DECISION DELEGATED TO HEAD OF PLANNING

Application No: H05-1007-23 **Applicant:** Belmont Contractors Ltd

Proposal: Residential development of 9 dwellings - approved under H05-0725-22. Modification of Condition 1 (determined plans), 2 & 3 (windows) and 7 (fencing details) to allow amendments to previously approved plans

Location: Land Off Old Main Road Fleet Hargate Spalding

PLOT ONE
FLOOR PLANS - PROPOSED
ELEVATIONS - PROPOSED

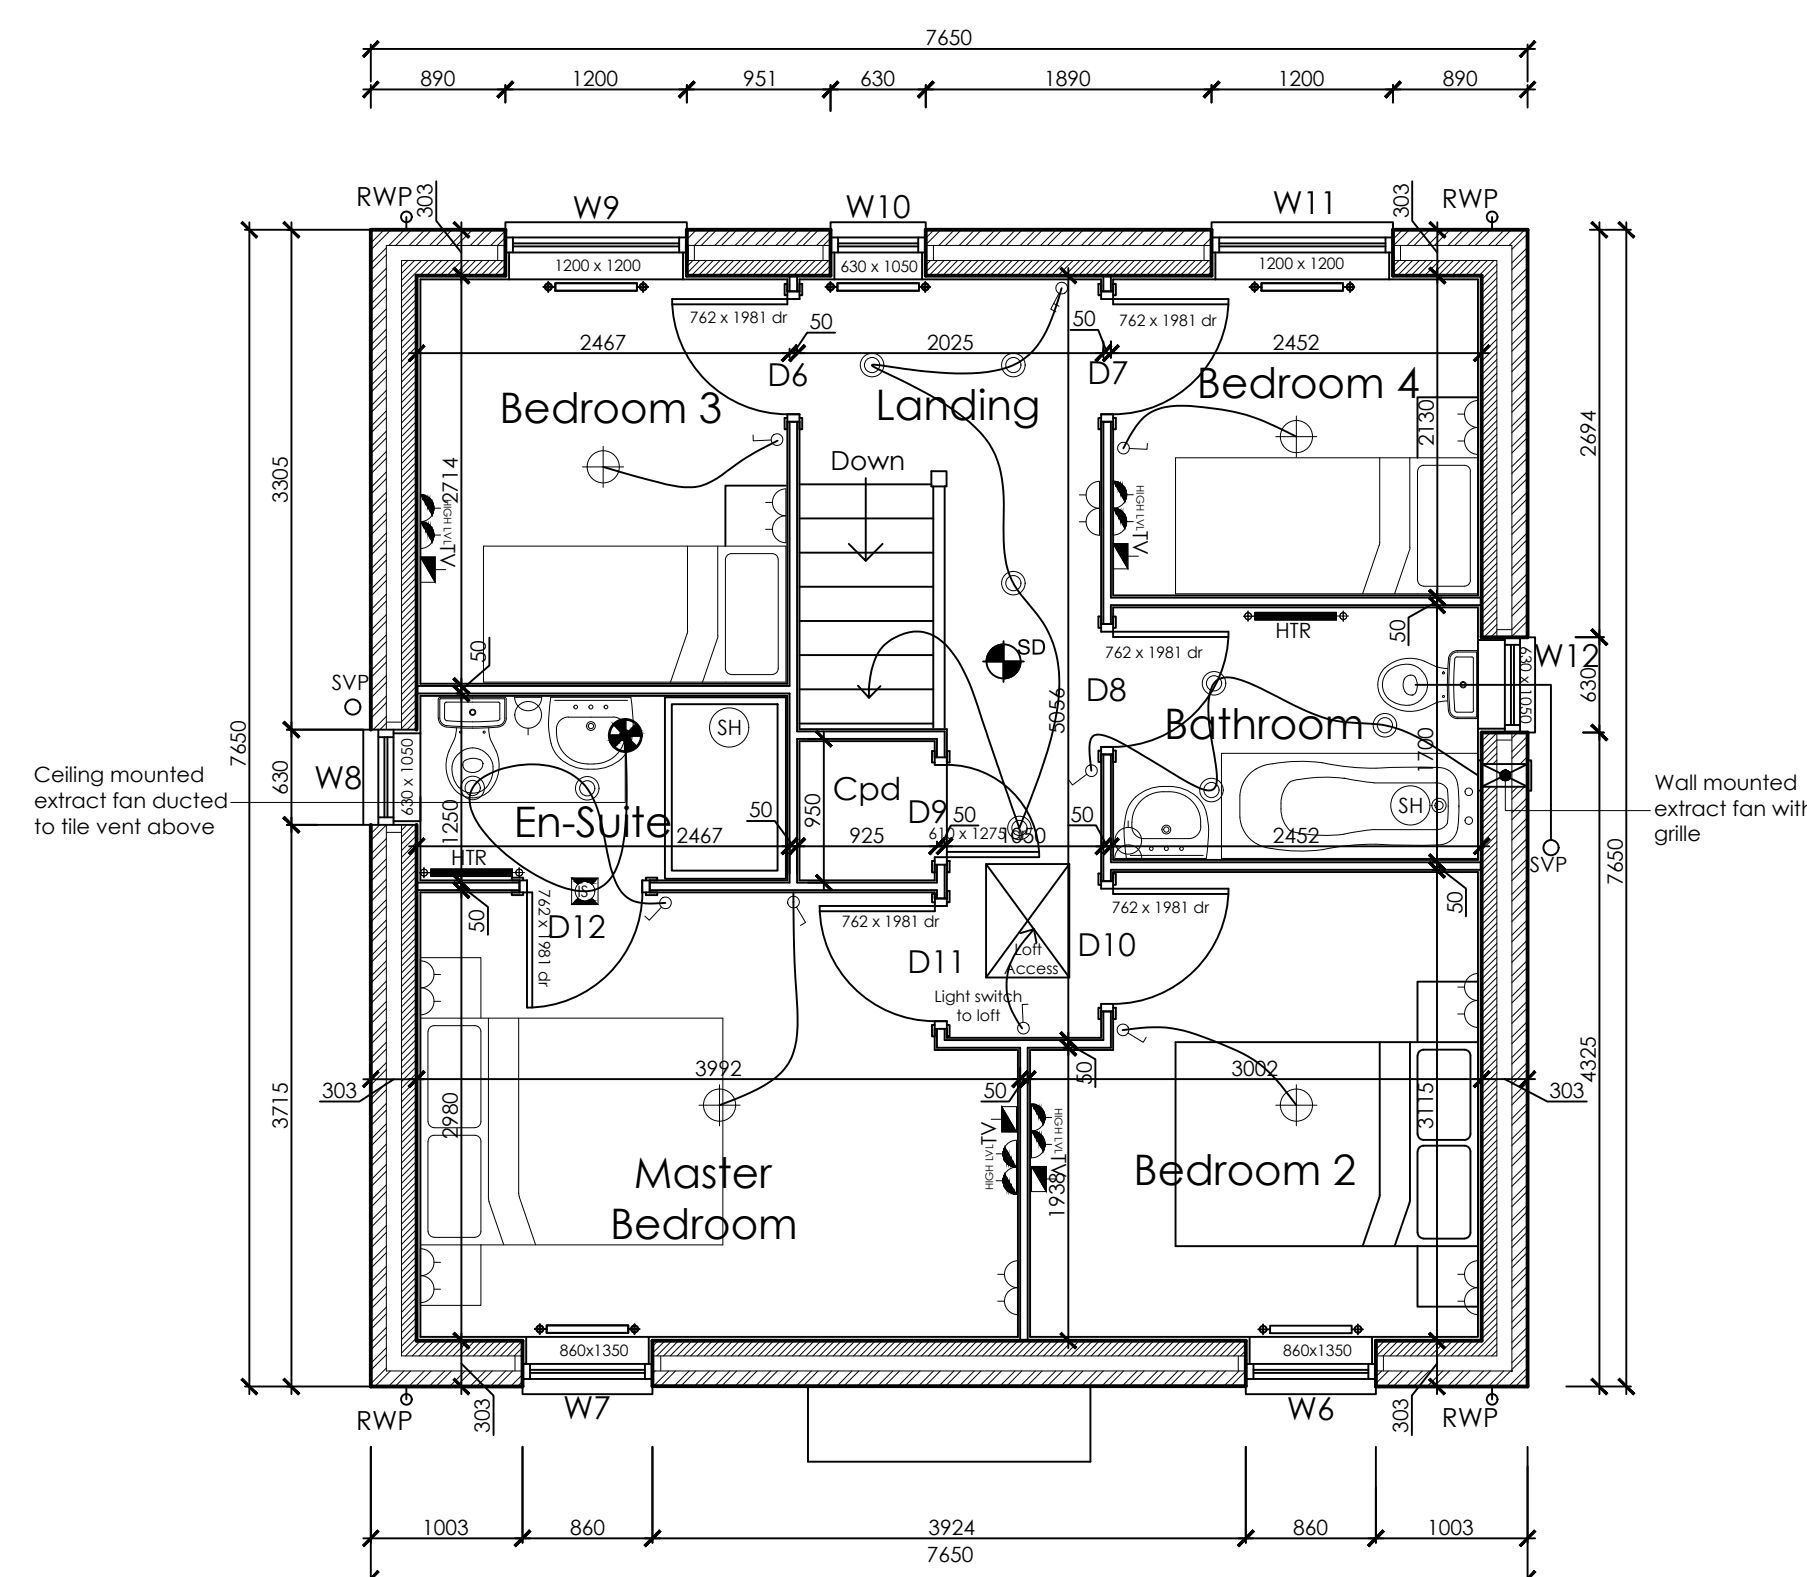
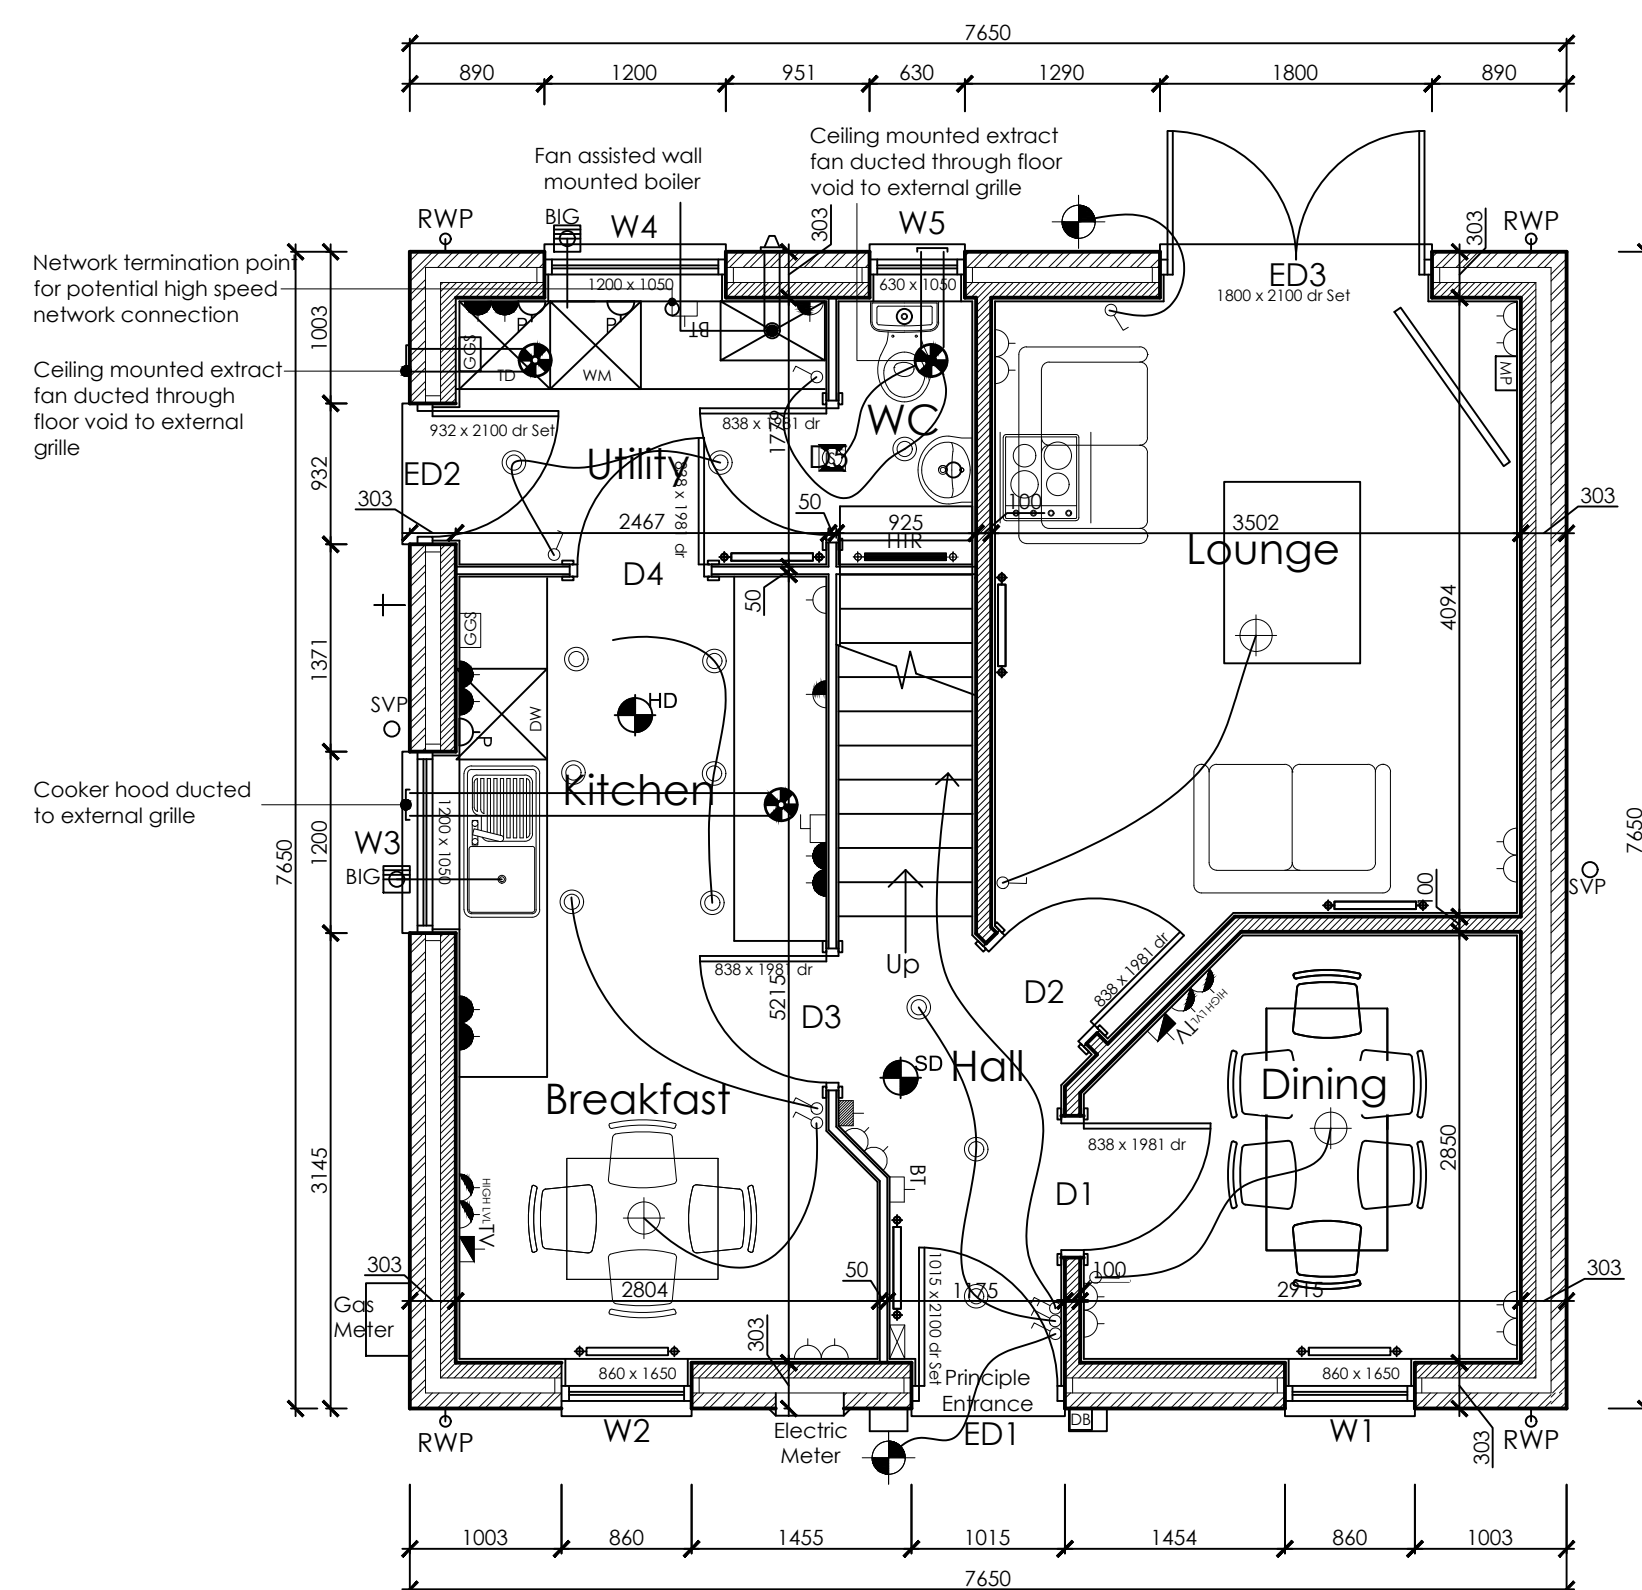
It is now proposed to include solar panels on the roof of all the properties, including on the front elevation of plot 1 because it is south facing. Although they would have a harmful impact upon the design of the properties and the character and appearance of the Conservation Area, it would be less than substantial.

It is now proposed to install uPVC, which is not normally considered acceptable within conservation areas. In this case, however, high quality conservation uPVC windows are proposed; namely, "Heritage Rose" uPVC sliding sash on the front elevation of plot 1 and "Residence 9" flush uPVC

casement windows elsewhere. They are specifically designed for conservation areas and are of a high standard of design and not readily indistinguishable from traditional timber windows. It should be noted that the R9 windows are flush so do not possess the normal characteristics of a standard uPVC window.

On balance, therefore, it is considered that the proposal satisfactorily accords with Policies 2, 3 and 29 of the South East Lincolnshire Local Plan and the provisions of the National Planning Policy Framework (December 2023).

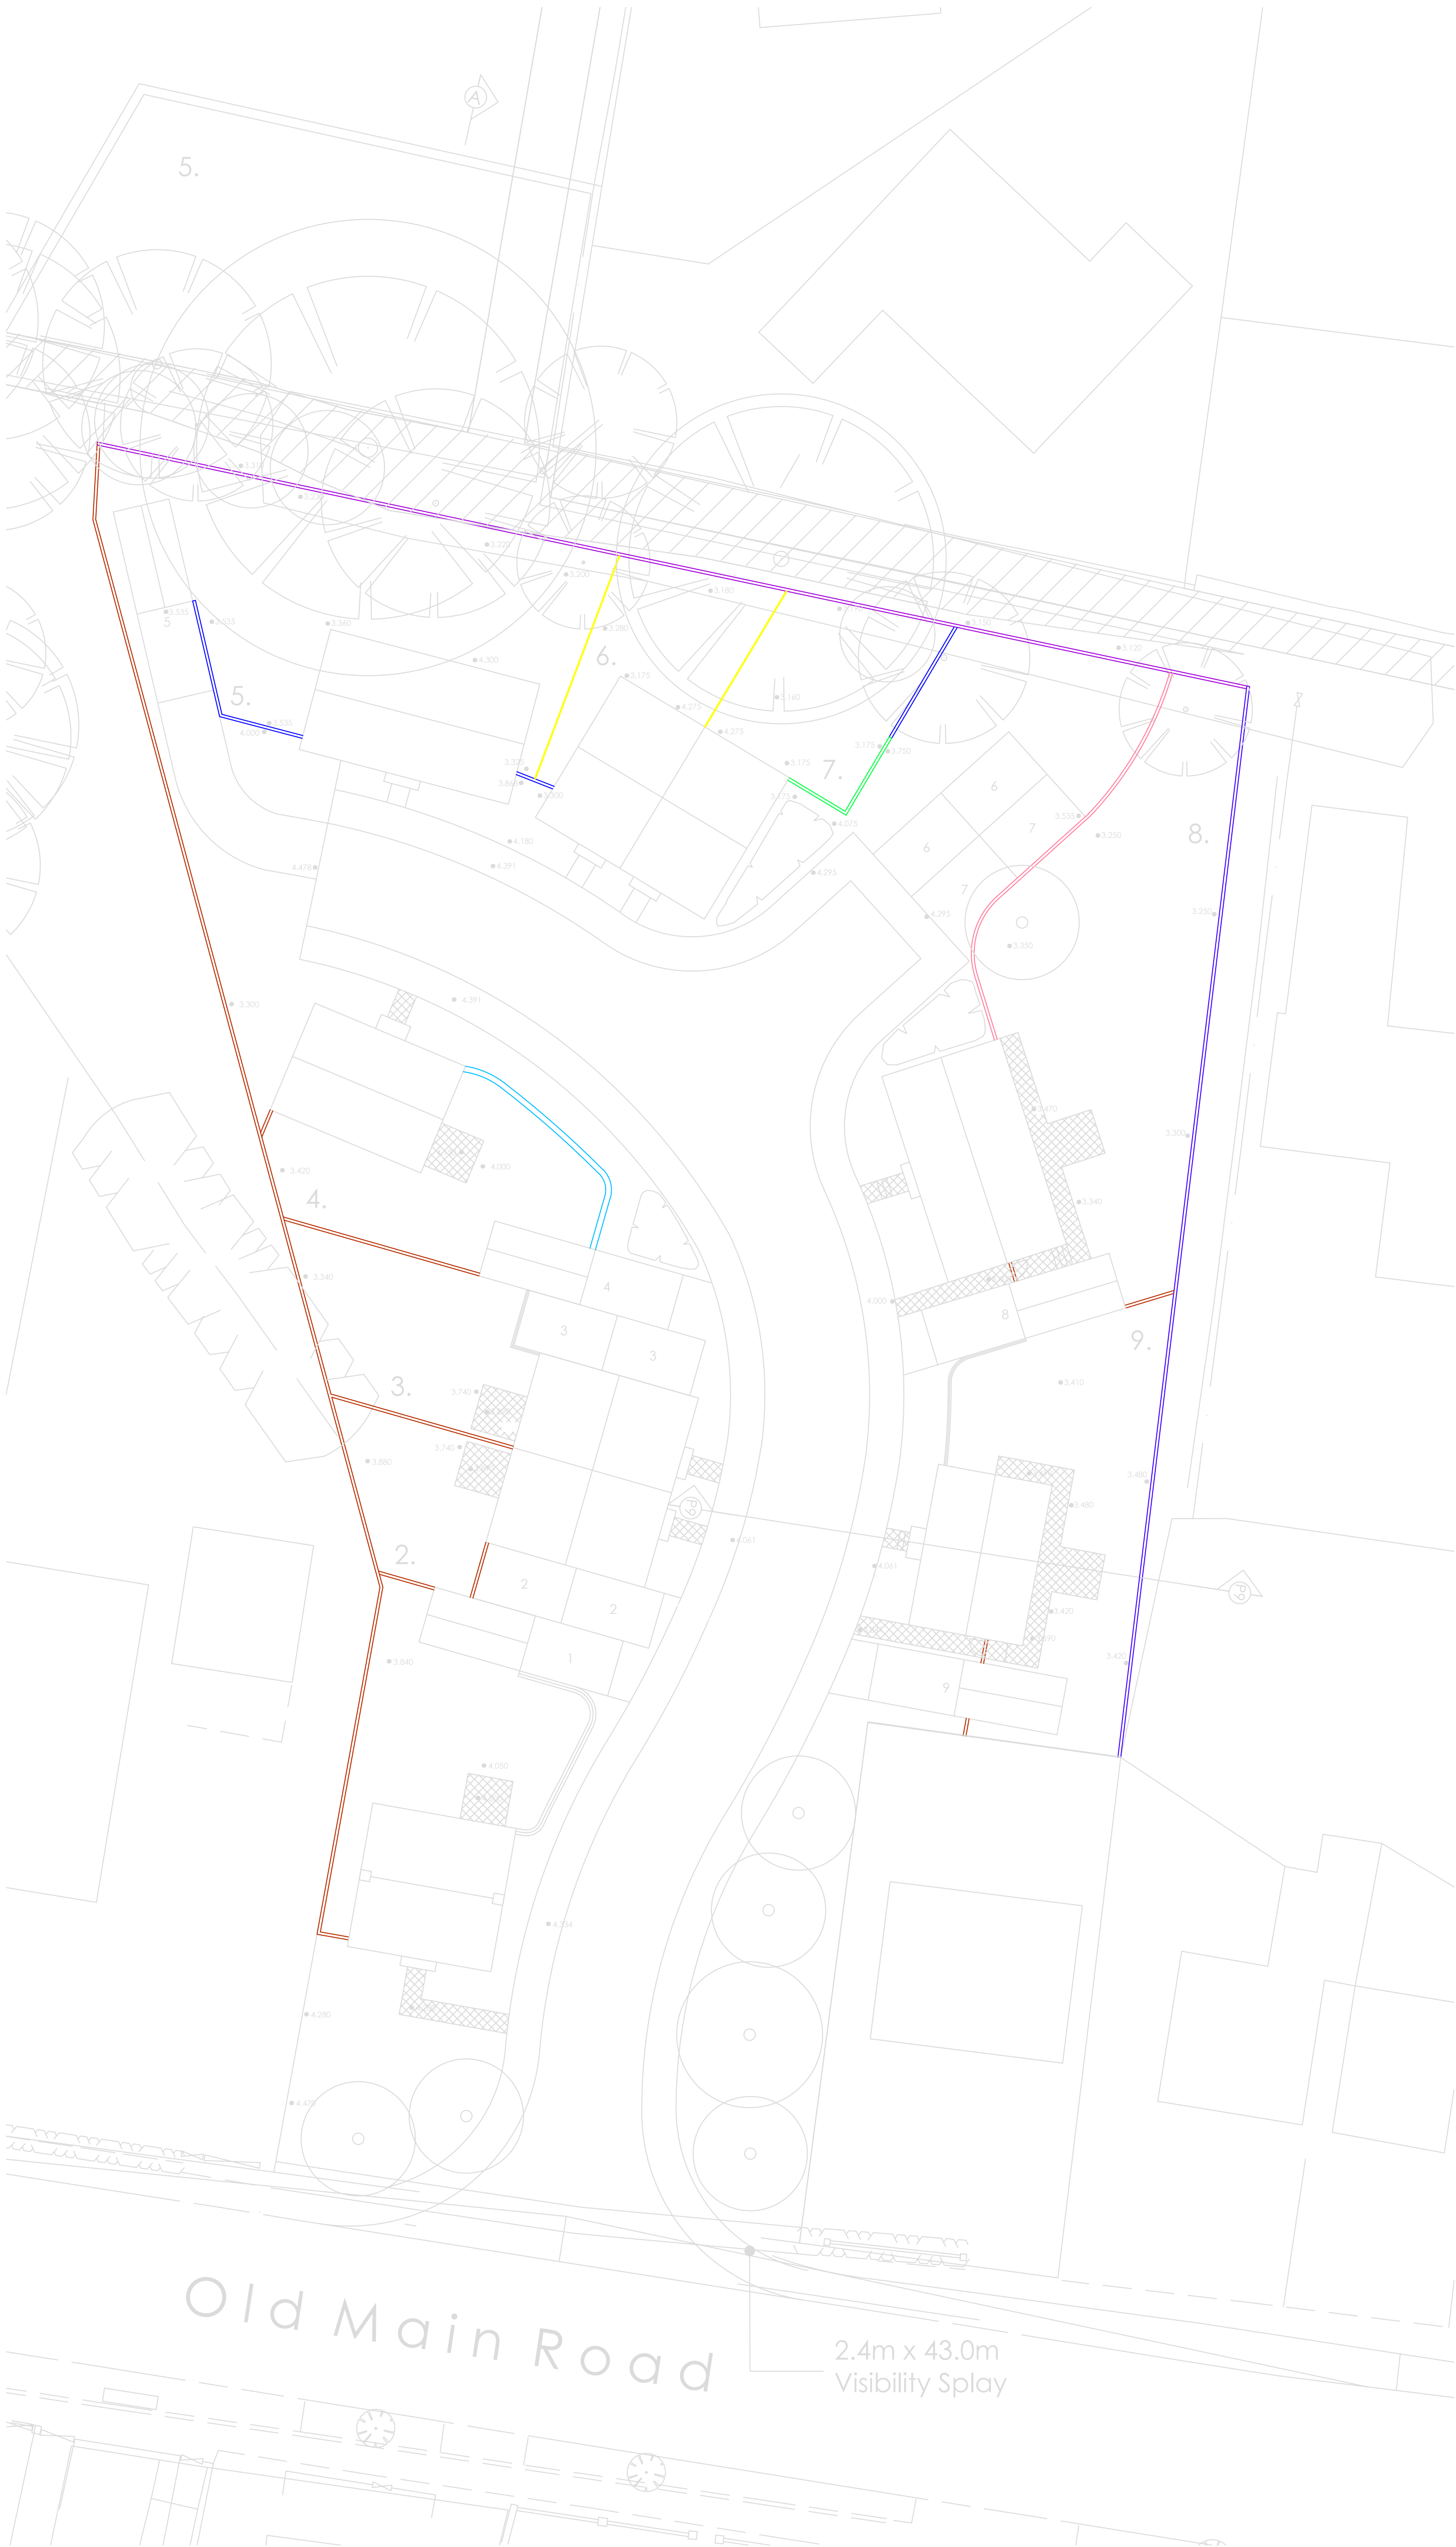
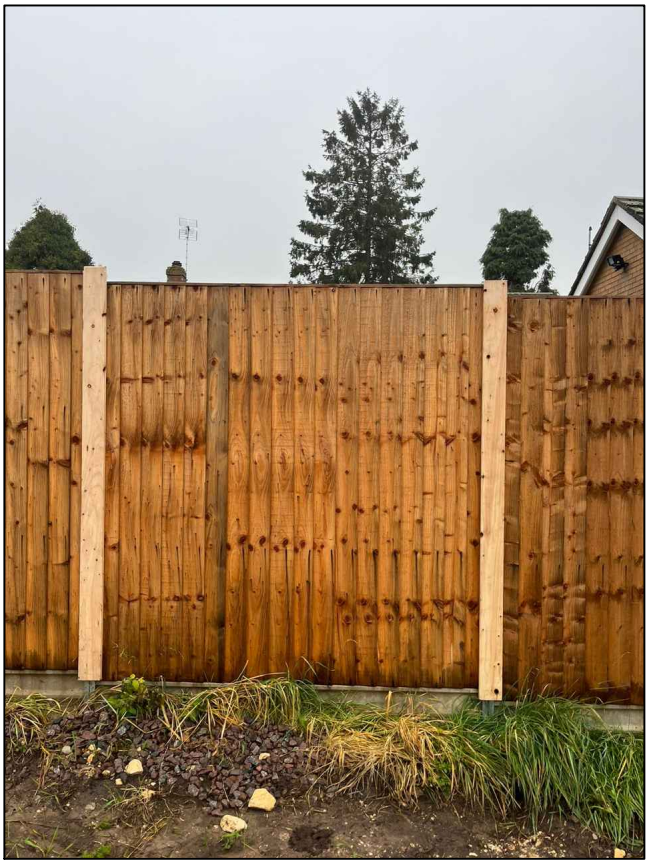
- Durable concrete posts have been replaced by inferior flimsy "tin" posts along eastern boundary. Concrete posts should be re-installed.

The main difference between the current proposal and that approved is the use of timber clad galvanised steel "Durapost" fence posts/supports as opposed to concrete posts in respect of fencing 1.8m high and above, including fencing along the eastern boundary. The latter has already been erected.

According to the applicant, the posts in question were chosen because "the size of post required along the eastern boundary was not readily available, so I looked at other options and came across this post. For us as a company it ticked multiple boxes, mainly the weight of this post compared with a concrete post meant it was a lot safer to lift and man handle by one person - the concrete equivalent being approx 80kgs." He goes on to confirm that "the gravel boards have been sealed as per the condition."

Whilst the "Duraposts" may appear rather flimsy, they are actually galvanised steel and have a H cross-section to provide strength and durability. The technical specification indicates that they are capable of withstanding strong winds up to 110mph and come with a 25 year guarantee. They are considered an acceptable alternative to concrete posts and preferable to timber.
